Technical Note 1

Project: Freda's Peanut Butter, Bee Mill, Ribchester

Subject: Transport Related Consultation Responses

Date: 15th December 2025

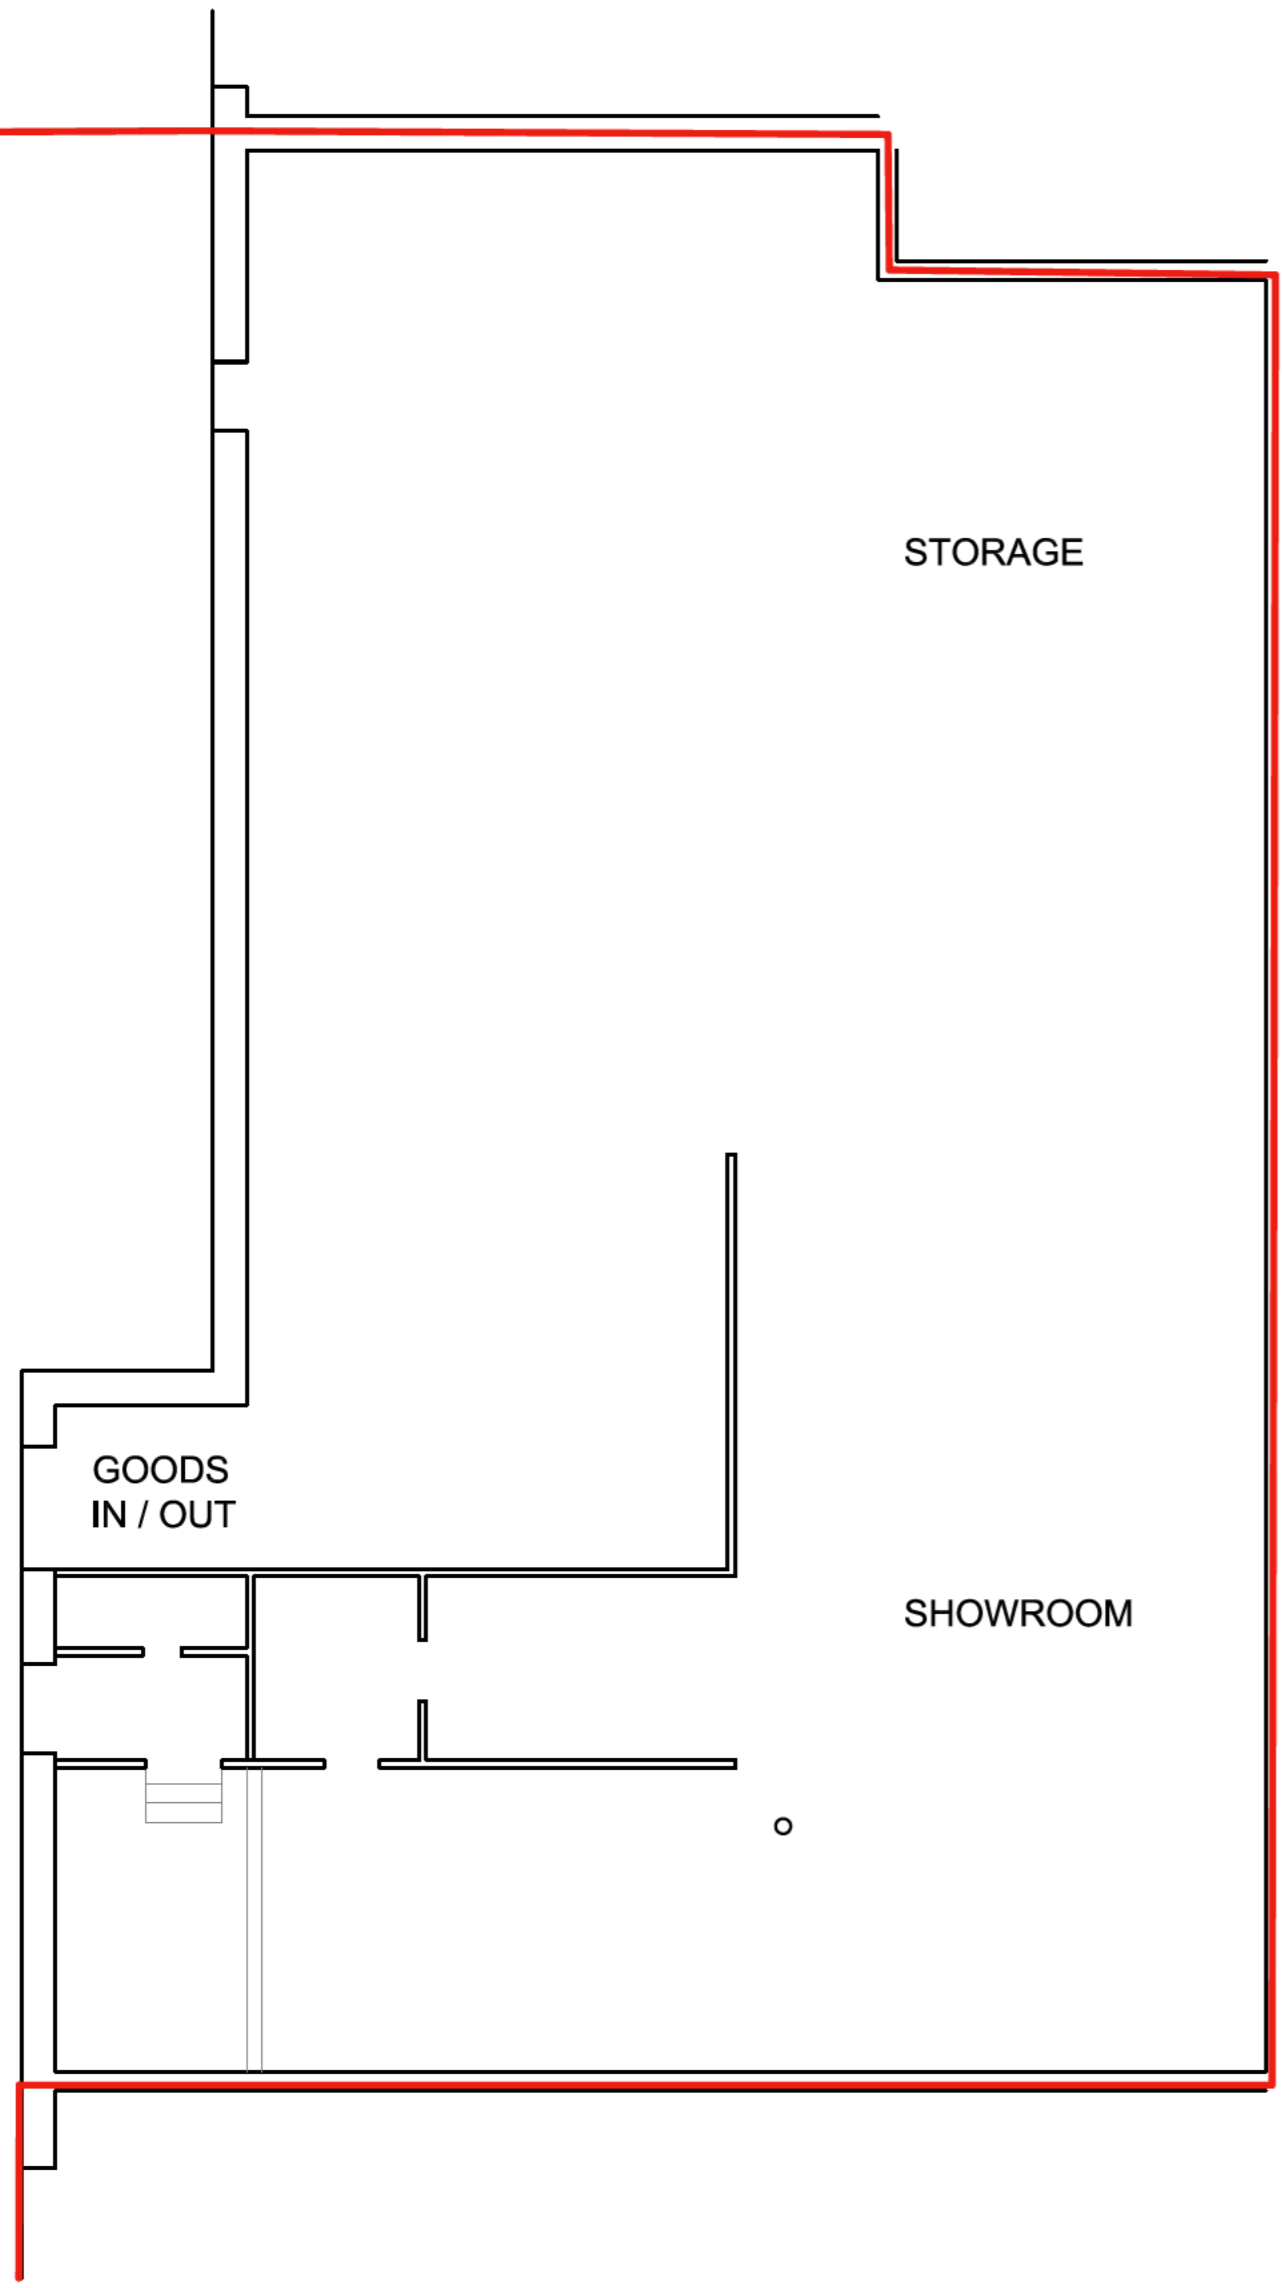
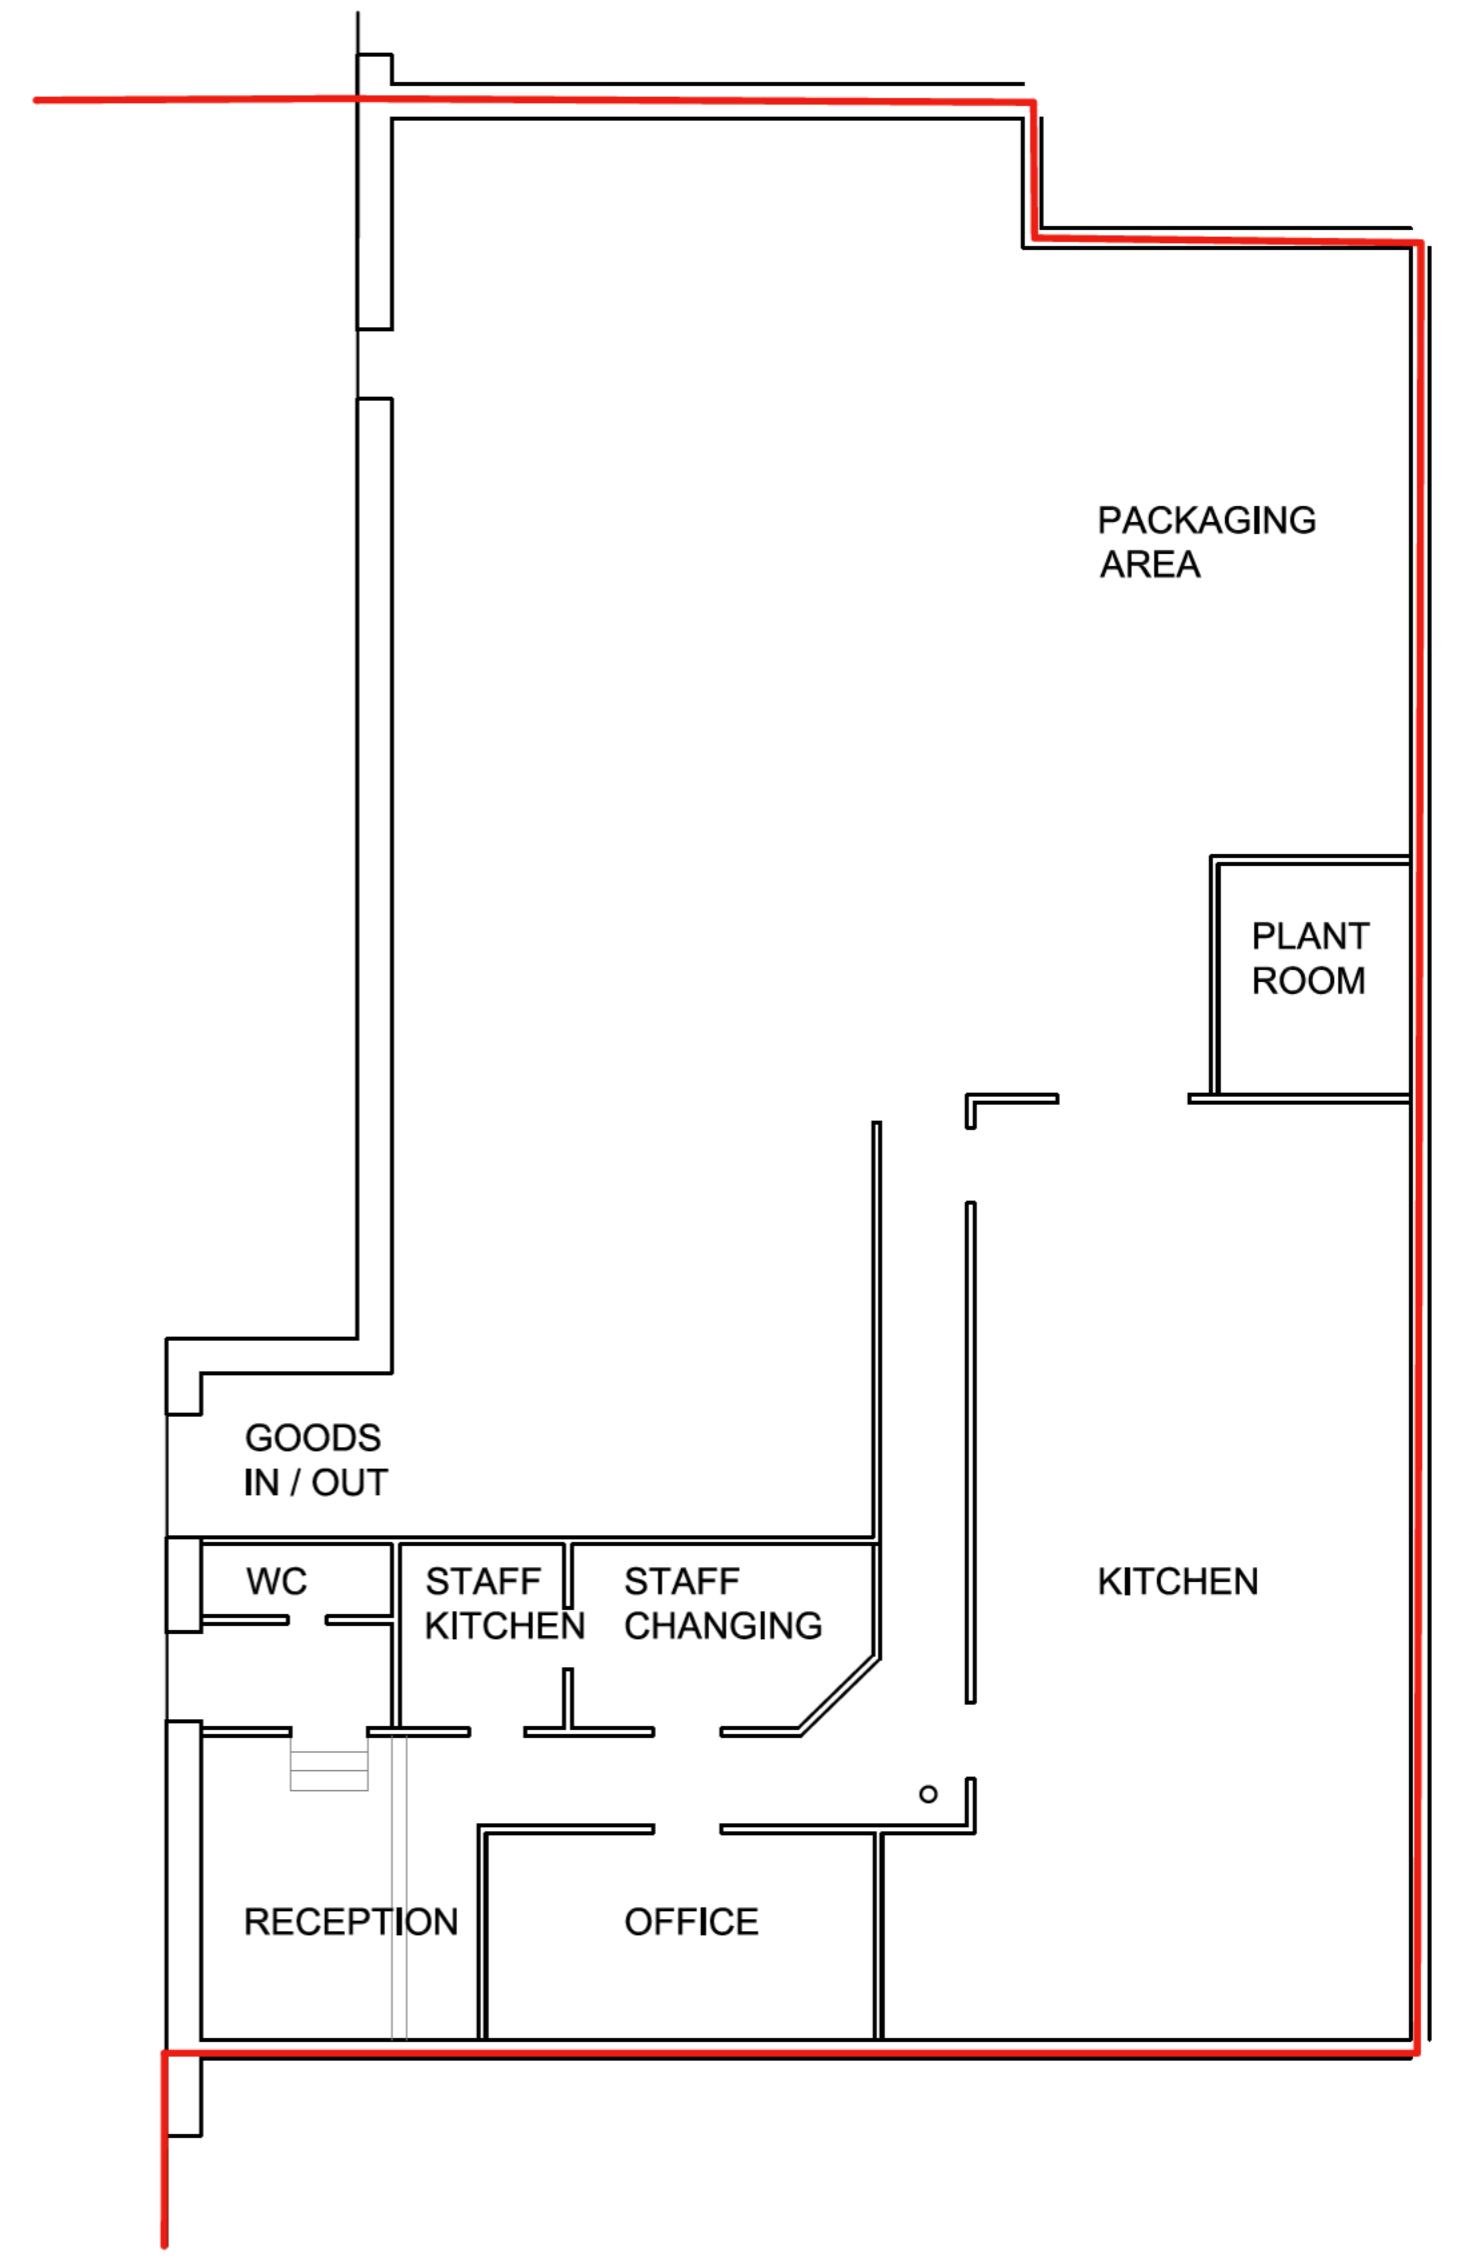
The LHA have reviewed the Existing and Proposed Plans and are aware that the internal gross floor area is 354 square meters. In line with the parking standards as defined in the Joint Lancashire Structure Plan a Class B2 use should provide parking at a ratio of 1 space per 45 square metres. Applying the Joint Lancashire Structure Plan parking standard yields a requirement of 8 parking spaces. The current provision, therefore, represents a shortfall of three spaces.

5. The Applicant has provided further information on the numbers of employees at the site in the short term as follows:

- 3 full time employees (which include one employee and the two owners of the business)
- 2 part-time employees who would likely work on separate days.

6. It should also be noted that the two owners would walk to the site as they reside nearby and as previously stated, customers do not visit the site with all sales going directly to retailers or directly to the customers via on-line sales. Accordingly, there would be a short-term demand for two car parking spaces on the site at any one time. The site would only operate during normal working hours (Monday to Friday).
